Our Ref: P/87/14/HH
Your Ref:

Application for Planning Permission for Works or Extension to a Dwelling

Development Retention of single storey timber shed

Location 172A Pagham Road Pagham

SITE PLAN

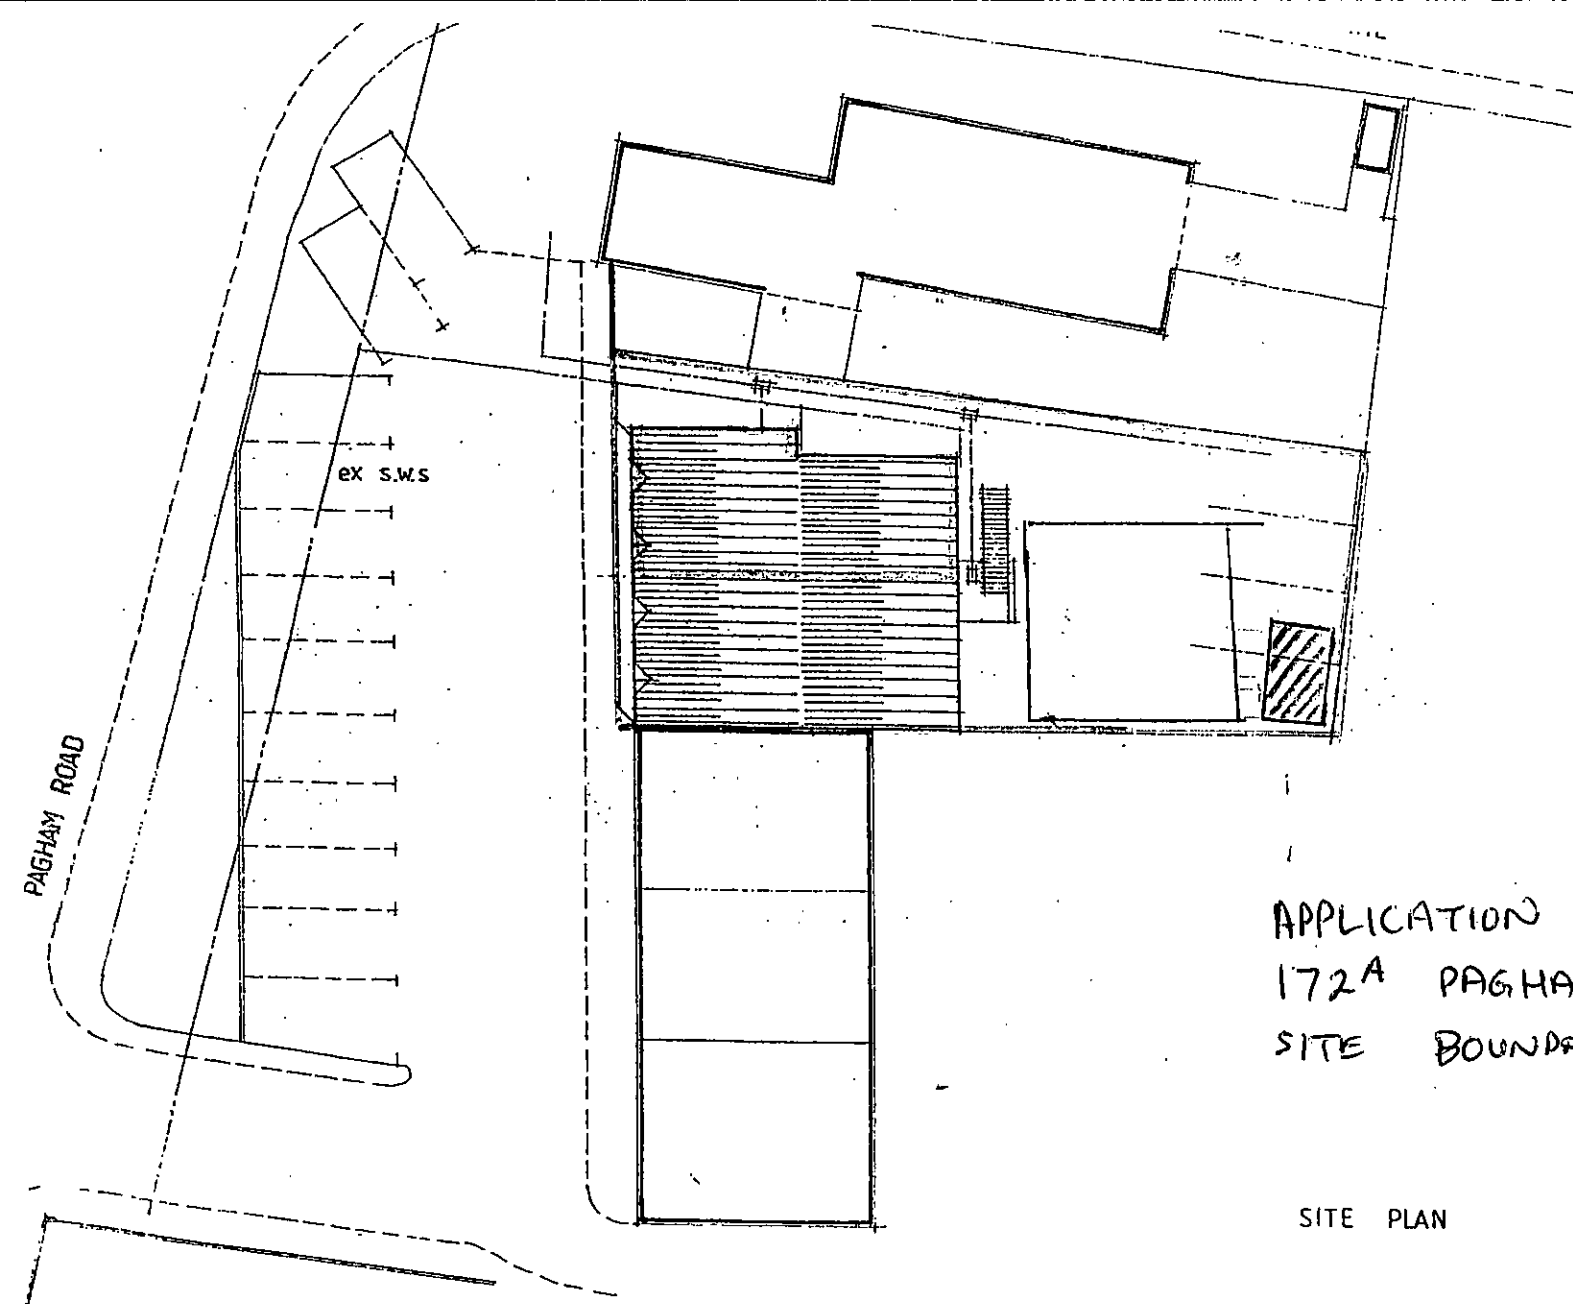
✓ Please submit 1 electronic or 3 paper copies of a revised block/site plan at a scale of 1:500 or 1:200 to include the site dimensions from the shed to the site boundaries. Further details of what must be included on the plan can be found in the National Validation Requirements.

FLOOR AND ELEVATION PLANS

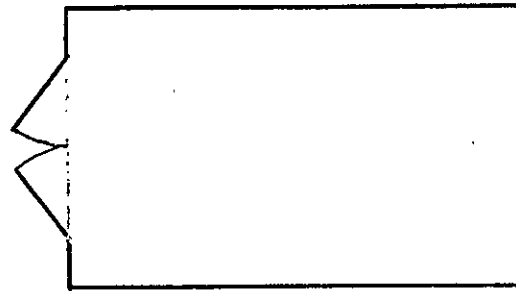
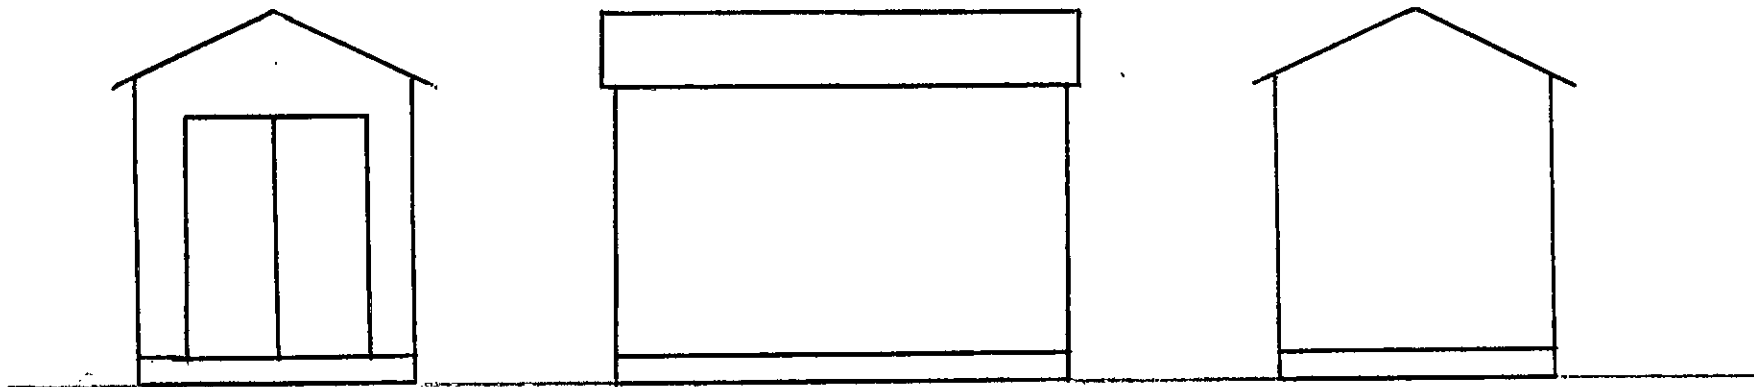
✓ Please submit 1 electronic or 3 paper copies of clearly labelled proposed floor plan of the shed at a scale of 1:50 or 1:100. Further details can be found in the National Validation Requirements.

✓ Please submit 1 electronic or 3 paper copies of clearly labelled proposed elevations of the shed at a scale of 1:50 or 1:100. Further details can be found in the National Validation Requirements.
